From: Charlotte Burrows on behalf of Planning.Responses
Sent: 14 September 2017 13:44
To: Planning Scanning
Subject: FW: FG/108/17/DOC - Condition 4 Internal Noise levels - Ferring
Attachments: JSL2159_101B.pdf

From: Carol Reynolds
Sent: 13 September 2017 11:09
To: Anita Gardner
Subject: RE: FG/108/17/DOC - Condition 4 Internal Noise levels - 1 Bennett Gardens, Ferring

Subject: FG/108/17/DOC - Condition 4 Internal Noise levels - 1 Bennett Gardens, Ferring

INTERNAL NOISE ASSESSMENT

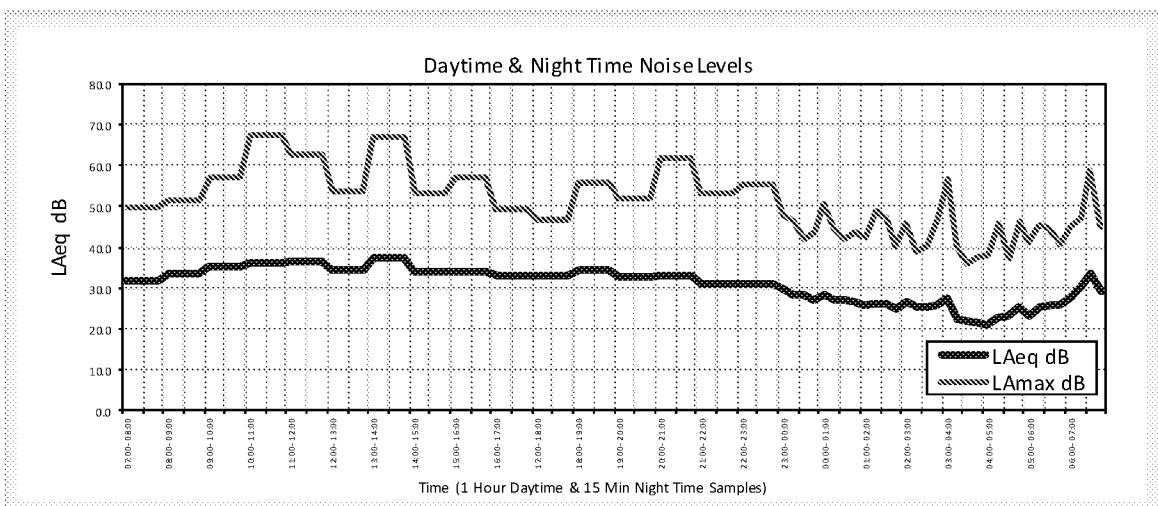
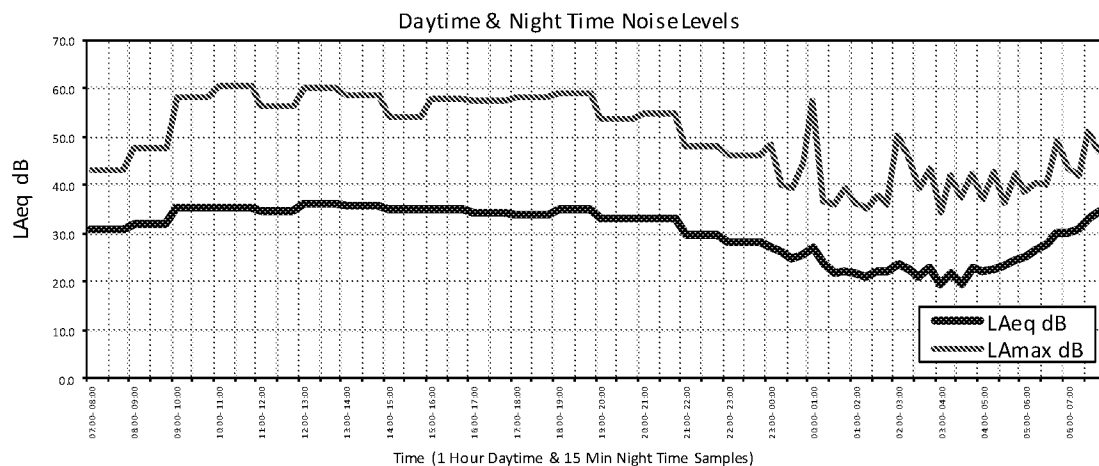
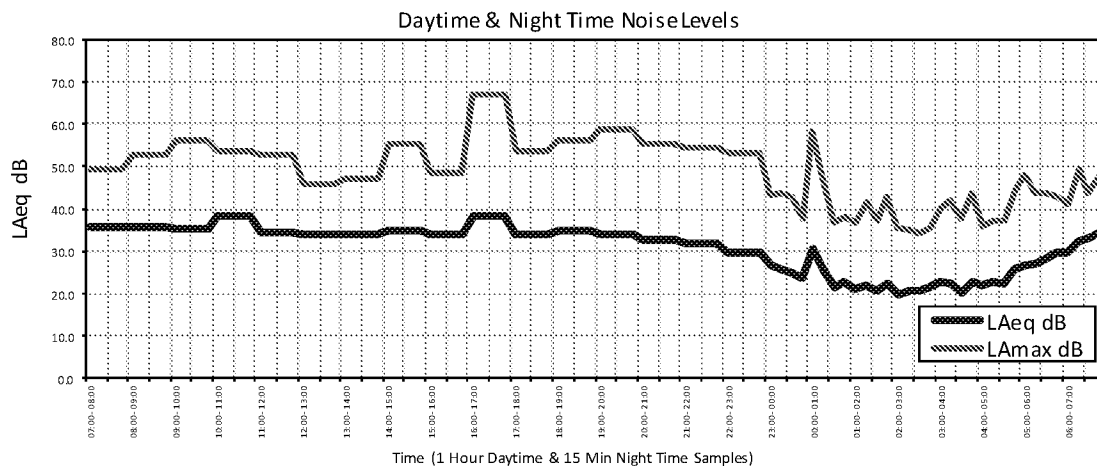
I write to confirm detail of our conversation, 24th August 2017, when I advised that the average sound level of those 2 rooms tested accords with the requirements of BS8233:2014, but not in respect of impact noise. The above reports clearly demonstrate the unacceptably high frequency of noise events affecting these rooms, defined as greater than 12 events of, or above 45dBLAFMax during the night time period 23:00 to 07:00hrs. This was on Saturday night 1st/2nd July 2017 (15 events) at Plot 4 and on each night, Saturday 24th/25th June 2017 (22 events); Sunday 25th/26th June 2017 (20 events) and Monday 26th/27th June 2017 (24 events) tested at Plot 40 (NB variance in house numbering).

'Refuse application for discharge of Condition 4 in respect of post validation testing to determine compliance with the requirements of BS8233:2014. Those Acoustic Reports provided by Sound Advice Acoustics Ltd, Ref SA -5031 in respect of Plot 1-4 (1st to 4th July 2017) and SA - 4993 in respect of Plot 37 - 40 (24th to 27th June 2017) clearly demonstrate an unacceptably high incidence of peak noise, defined as 45dBLAFMax, within first floor bedrooms during night time hours. This is despite investigations having taken place predominantly over the week end, when traffic flow might be expected to be less. Please provide detail of those further mitigation measures which will be provided to achieve the required standard. Any further post completion validation testing to be carried out on at least 2 days within that period Monday to Friday.

With regards to the comments recently received from the local councils Environmental Health Department we would like to confirm that our past testing noise report and assessed noise levels have been conducted strictly in accordance with BS 8233 : 2014 as requested within the aforementioned planning condition. For verification, BS 8233 : 2014 does not set nor require any LAmax dB criteria for internal noise levels within bedroom. Furthermore, the planning condition does not request post testing for LAmax dB noise levels.

Therefore the noise report issued has demonstrated compliance with BS 8233 : 2014 and the planning condition should be discharged accordingly.

I would also like to state that with the submitted testing report for both blocks they were tested in the most affected flat/room by noise from the A259 of block 1-4 and block 37-40. Testing the worst case scenario and showing it passes should negate any need to test other rooms that are less impacted, especially with the ground floor benefitting from the 2.5m acoustic fencing.

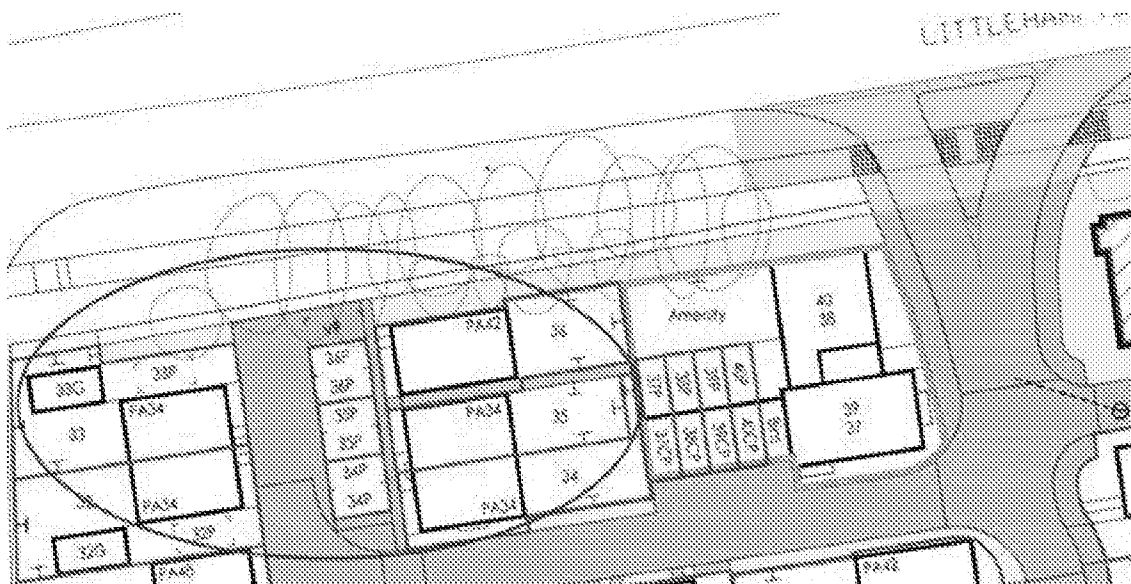
My question was regarding the remaining units which as you will see in the below image have only plot 36 adjacent to the a259 with 35 and 34 protected by 36.

We intend on carrying out the testing in 2 weeks time so to avoid any disruption I wanted to check if this was an error and instead the condition should state 33 and 36 or if you would like me to carry out testing to the 3 units listed in the condition?

Going forward we still are due to test more plots alongside the A259. The condition does ask for testing of 3 plots (34-36) however only one of those plots front on to the A259 and we intend on testing the two left on site that do (33 and 36). Please see the exert of the site below for reference.

Can you please confirm that you would like Taylor Wimpey to test plots 33 and 36 instead of what is stated in the condition as 34-36 that contains two units that are shielded by plot 36 or if you would like us to test all 3 units as stated?
